LORSON RANCH  
Carriage Meadows North Landscape Preliminary Plan

Lorson Ranch  
Carriage Meadows North

PRELIMINARY LANDSCAPE PLAN

Lorson Ranch
Carriage Meadows North
Colorado Springs, CO
PRELIMINARY LANDSCAPE PLAN

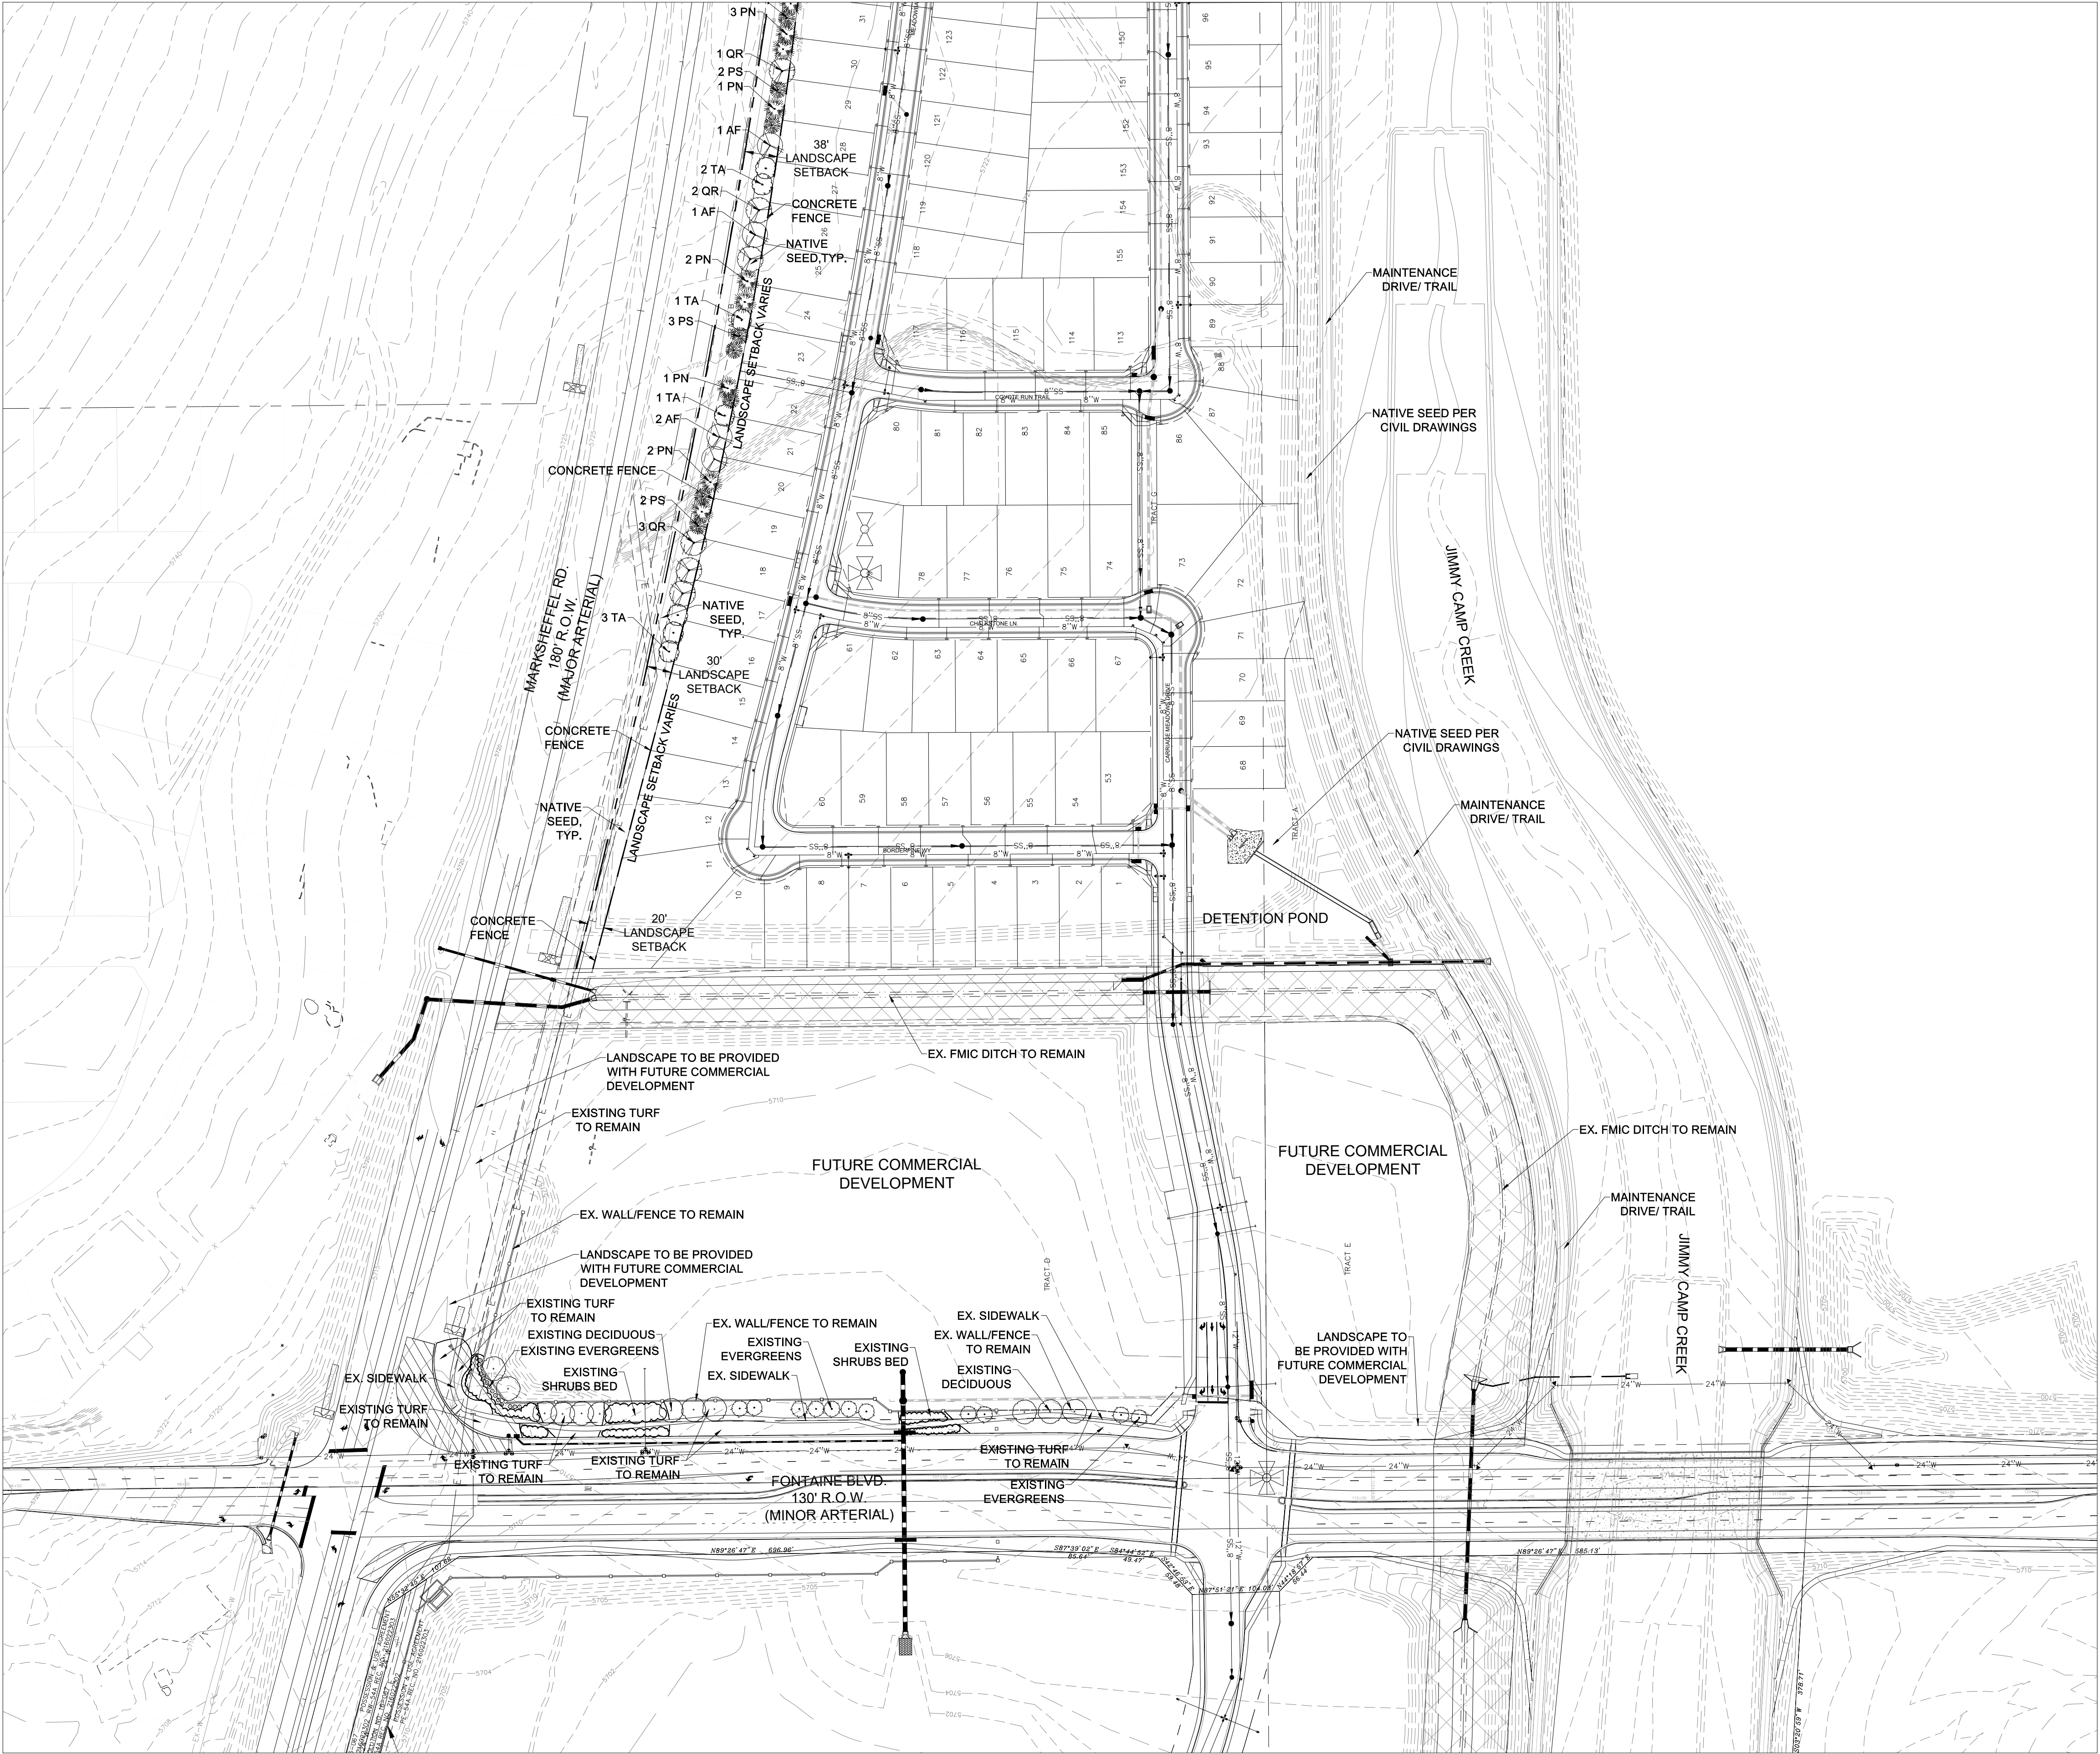
Provide the data table provided / REQ Plant species symbols, setbacks etc....The PUD refers to the Code for the requirements. pertaining to this PUD. Marksheffel is a principal arterial (on first sheet); Fontaine Blvd. is minor arterial at this location. The arterials are required to be landscaped, the residential collectors internal are not. Commercial development is proposed across Fontaine Blvd to the south.

A plat note referencing the landscape plan and a line for the redecoration number. shall be added. The landscape plan will be recorded as an exhibit to the plat.

Identify trai

Label the FMIC easement if in section

What happened to Fontaine? Show Fontaine and landscape along it. Is there fencing?

Why does the landscape plan stop and not continue along the remaining lots? It should extend to the boundary as well as the boundary being depicted on the LS plan

Identify the landscape distance setback-  
identify where it is reduced due to ROW for  
Marksheffel
